Re: Response to Submissions - Integra Mine Complex Modification 1 Environmental Assessment

Table 1 Response to submissions on Integra Mine Complex Modification 1 EA

Complex overview

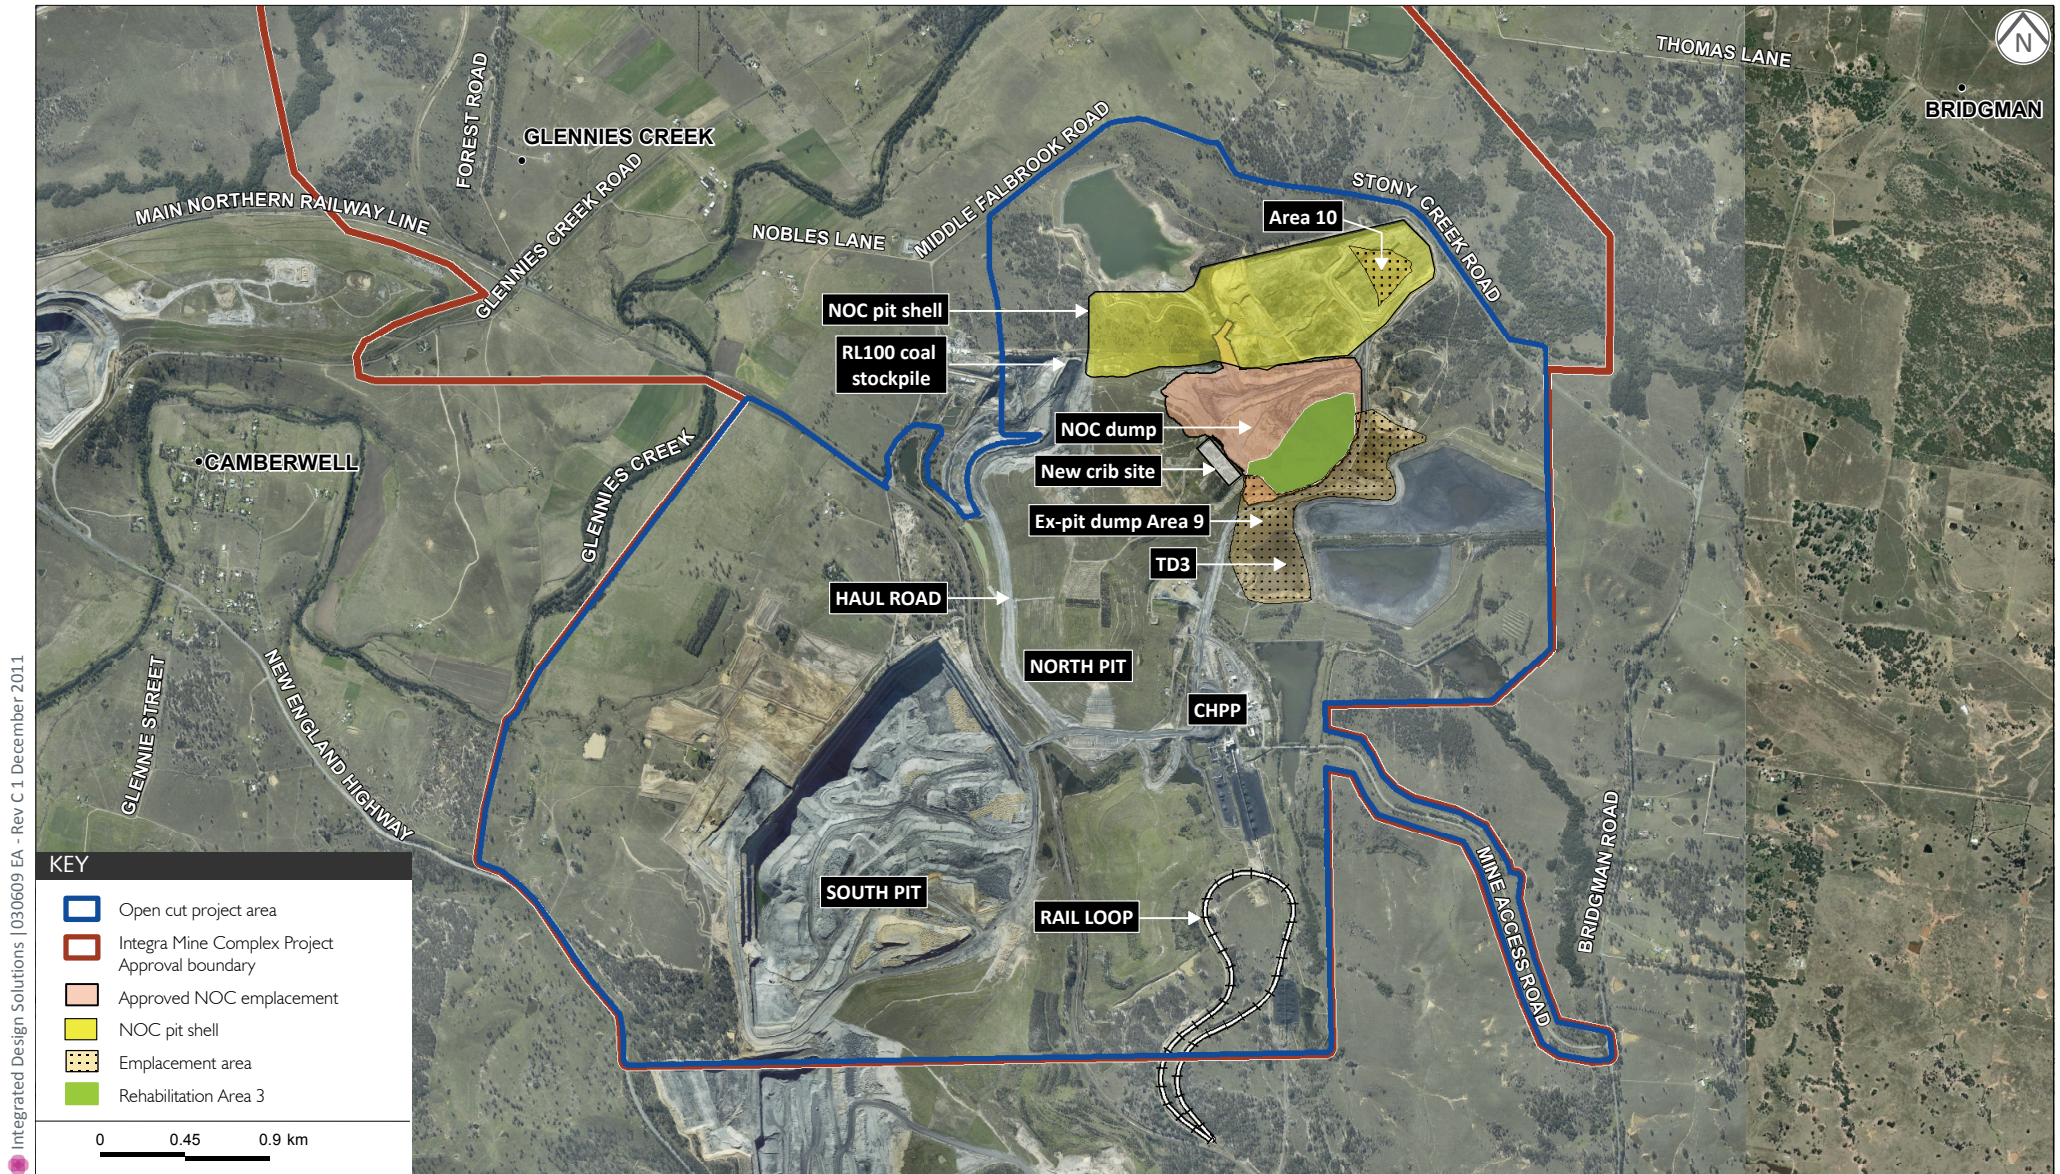
Subject to the above, NOW does not oppose the modification.	Noted.
DRE	
DRE supports approval of the modifications sought by Integra.	Noted.
Section 3.1 of the EA incorrectly states that the currently approved Mine Operation Plan allows for out-of-pit emplacement to 145 m AHD.	Noted.
CFMEU	
Considers that on balance the overall potential impacts of the modification are consistent with the project approvals and objectives of the EP&A Act and therefore supports the application.	Noted.
EPA	
EPA does not support modification application or extension of time for biodiversity offset strategy.	Noted.
It appears that the northern section of ex-pit dump Area 9 overlaps the southern portion of the Southern Biodiversity Offset Area. If encroachment by ex-pit Area 9 is proposed Vale will need to identify measures to be employed to prevent impact on the Southern Biodiversity Offset Area.	Ex-pit dump Area 9 as indicated within Figure 3.1 from the Integra Mine Complex Modification 1 Environmental Assessment has been revised by reducing the extent of dumping and no longer proposes to overlap the southern limit of the Southern Biodiversity Offset area. The environmental impact of reducing the extent of Area 9 is considered to be negligible. Please see attached updated figure.
